6 April 2020

File No: 2020/109789
Our Ref: R/2017/25/B
Your Ref: SSD-8924 & SSD-8925

Request for advice – The new Sydney Fish Markets – Concept and Stage 1 (SSD-8924) and Stage 2 (SSD-8925) – Response to Submissions (RtS)

PROMENADE STAIRS - WEST PLAN PLUG IN FURNITURE

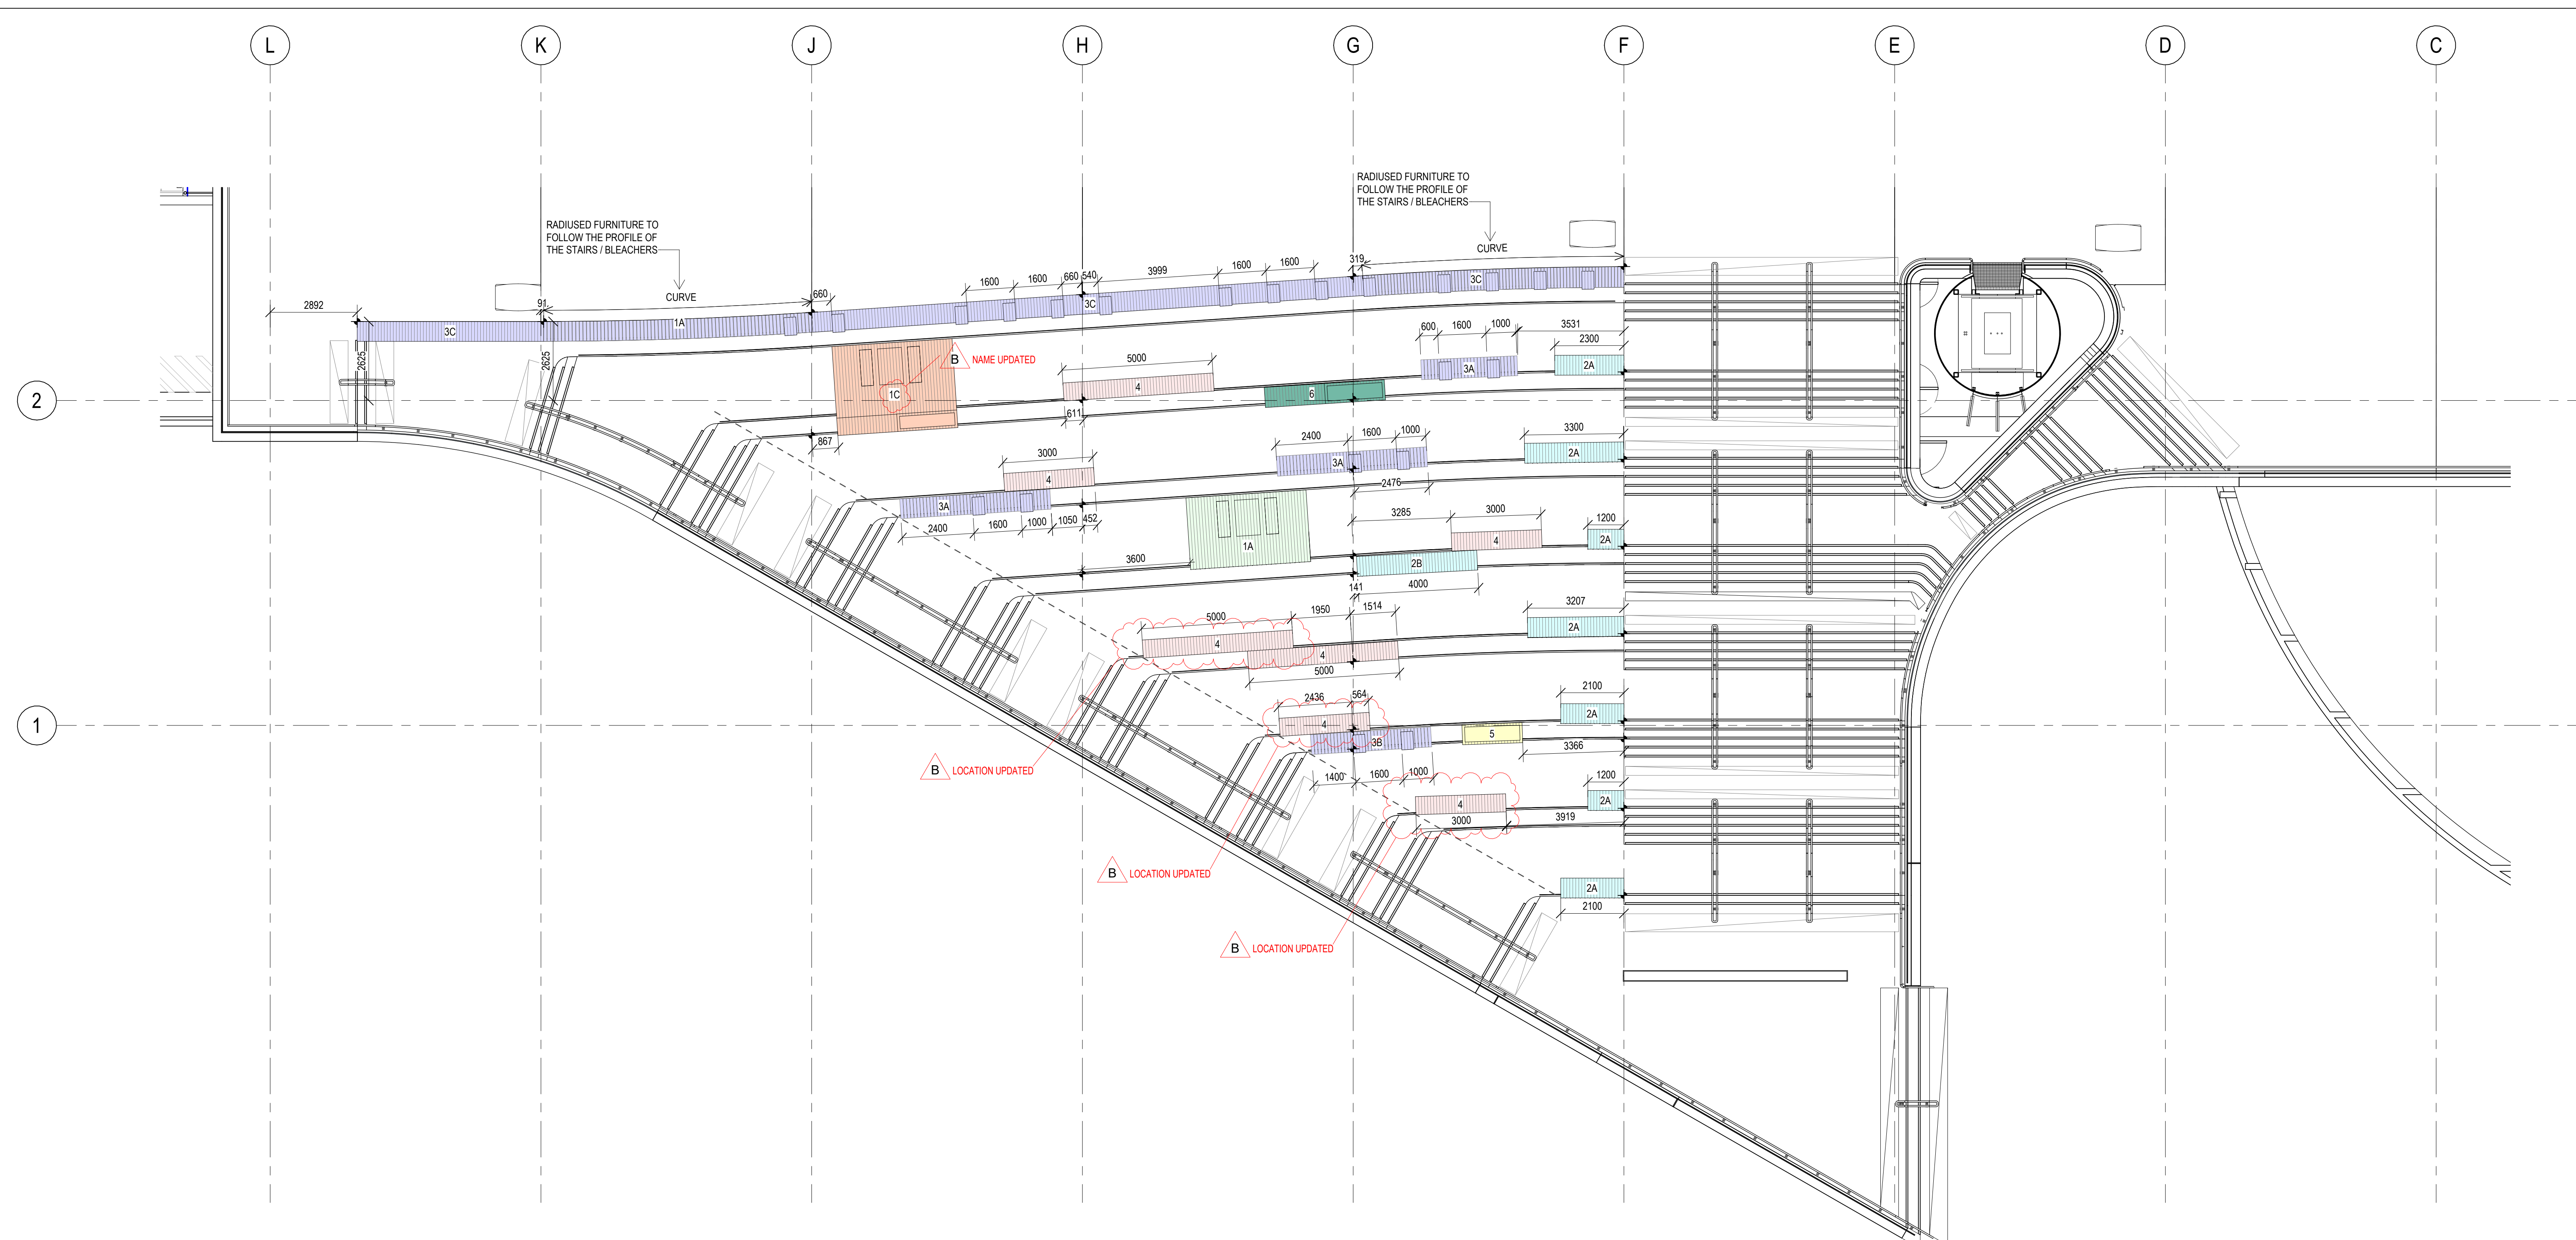
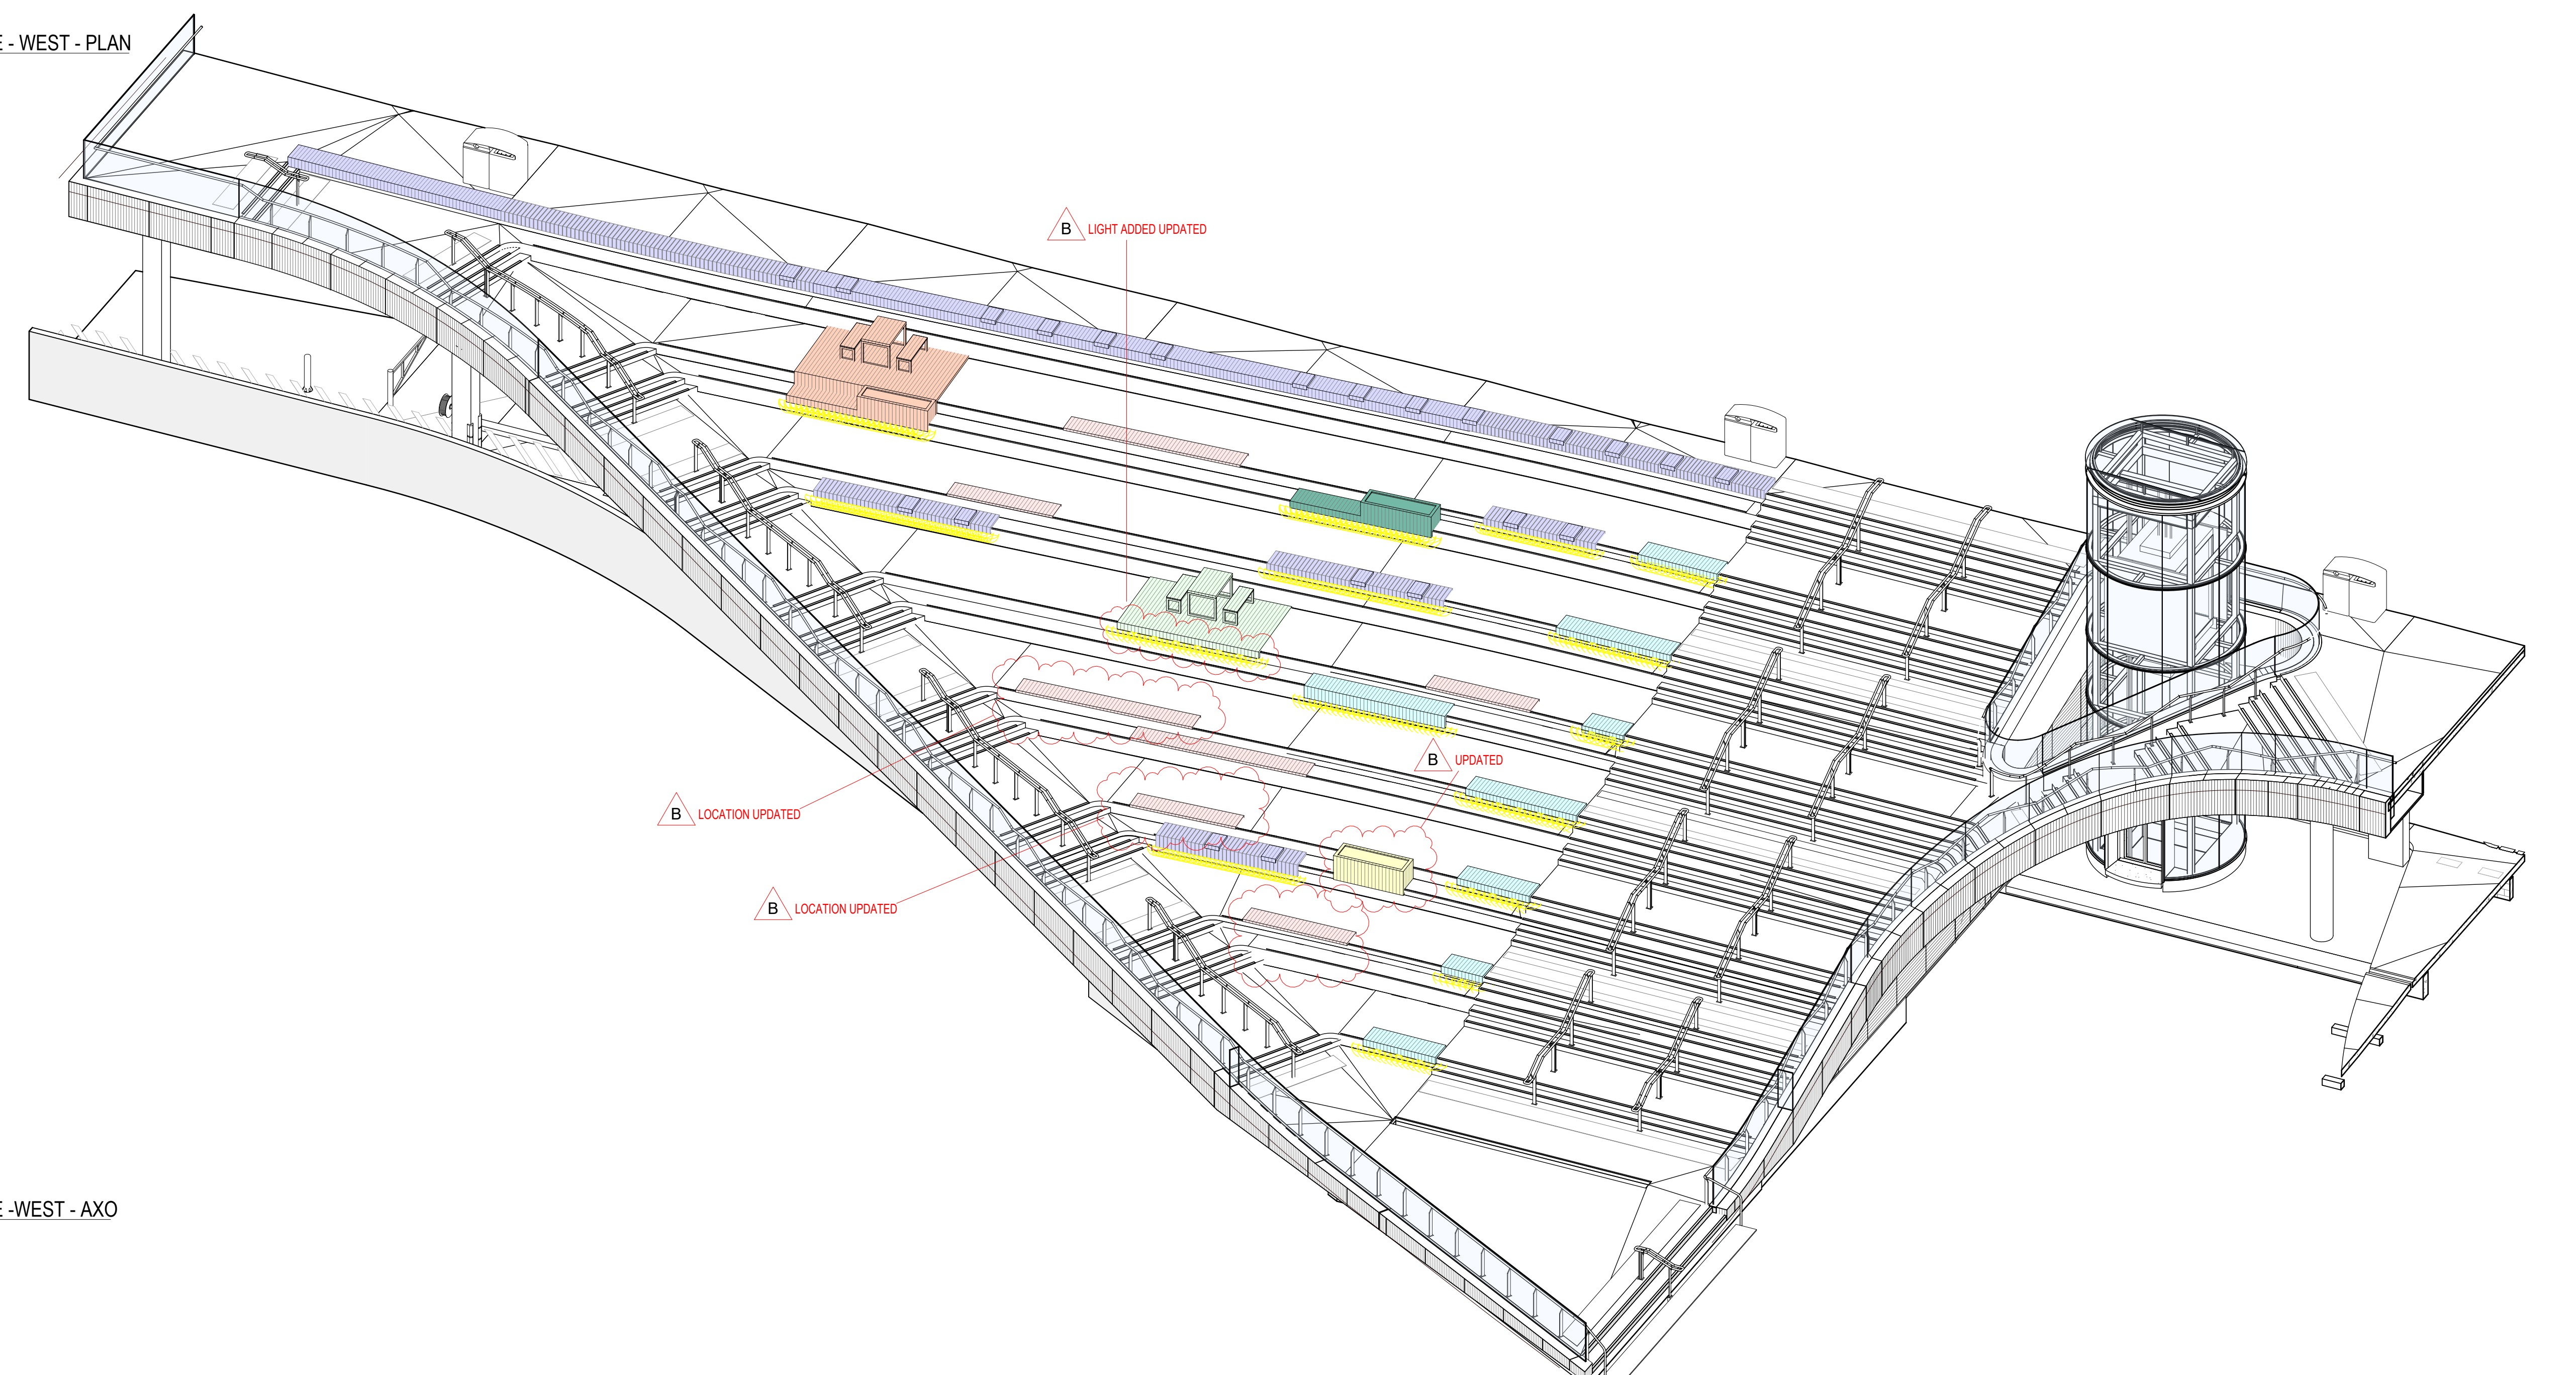
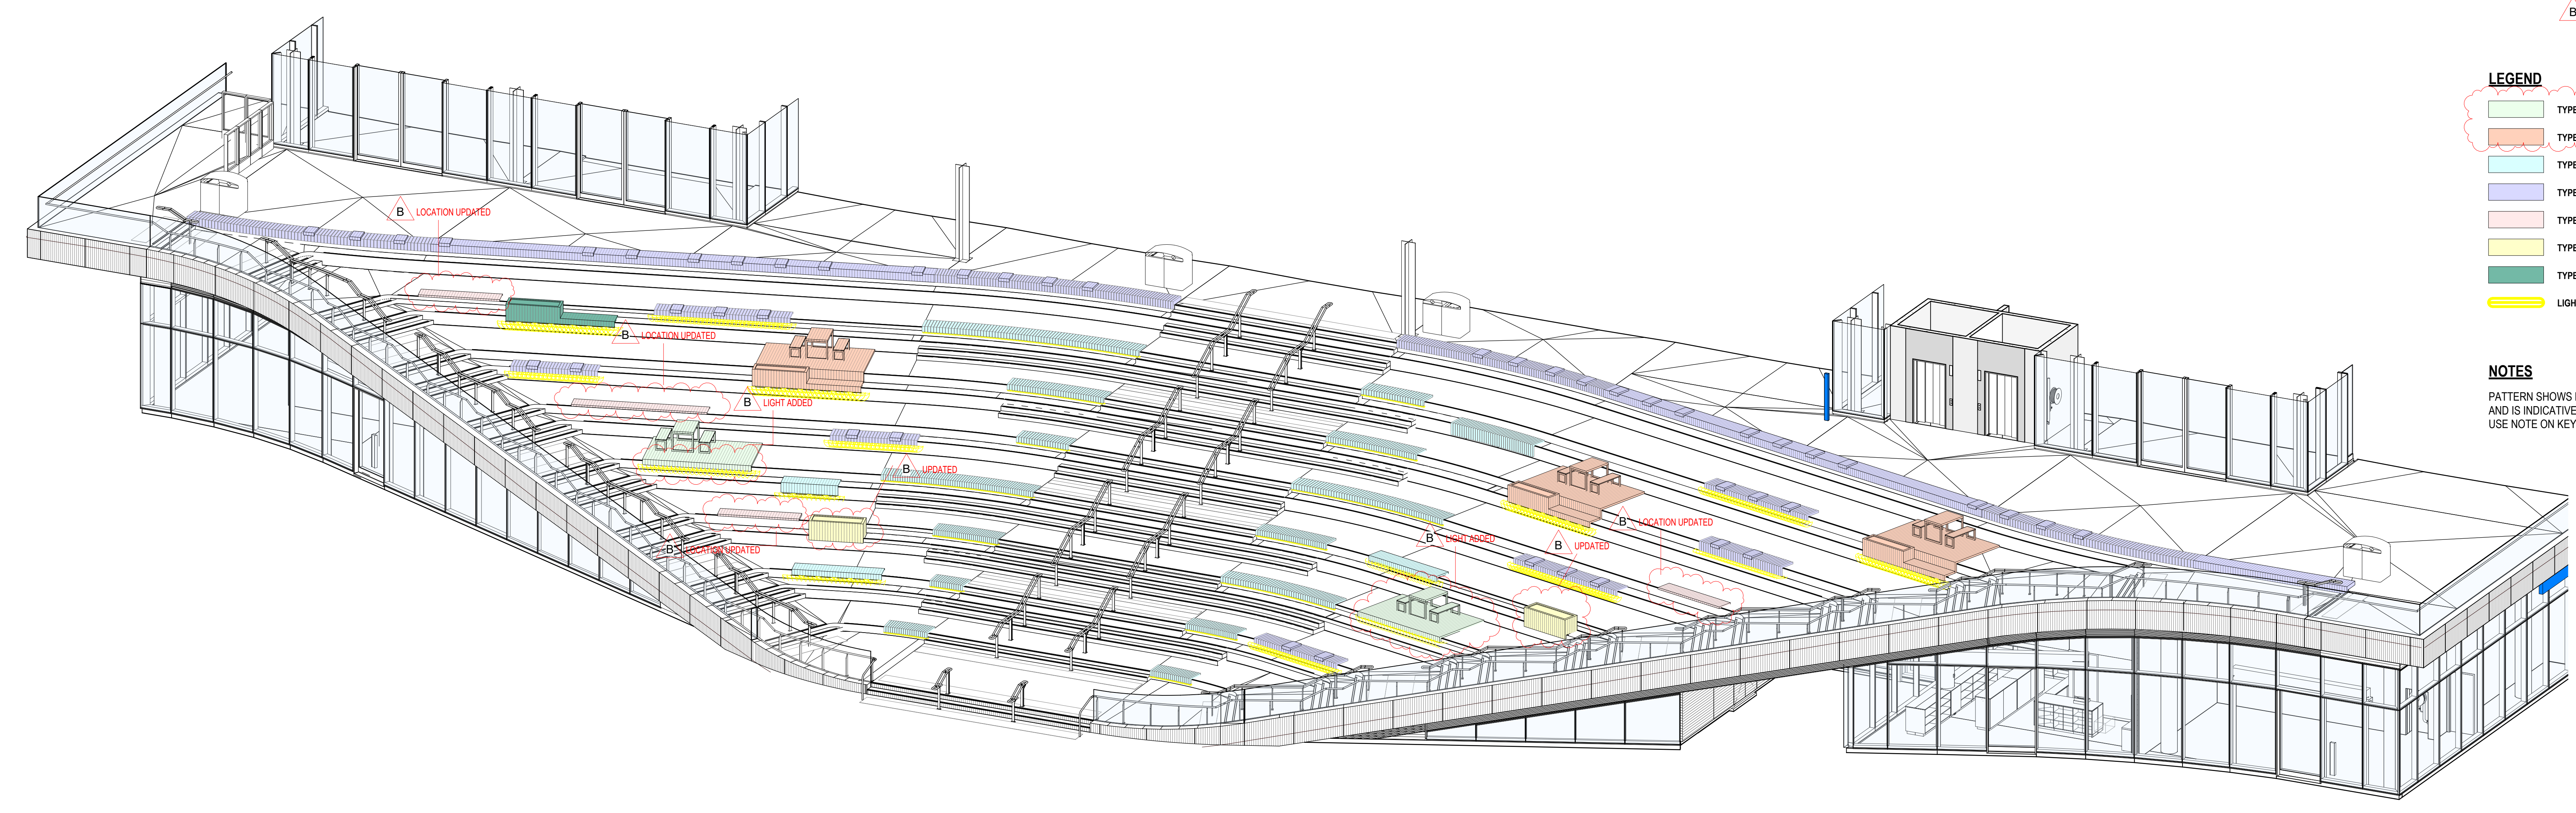
Further, the RtS advises that there will be ample opportunities for pedestrian movement and for 'stopping and relaxing' around the publicly accessible perimeter on the northern side of the upper promenade. However, no fixed furniture or fixtures are shown in this area in Part 3.0 of the Architecture and Public Domain Concept Design.

It is recommended that genuine opportunities for multiple public rest, beyond sitting at a cafe/restaurant, be provided to the public all along the northern side of the upper promenade.
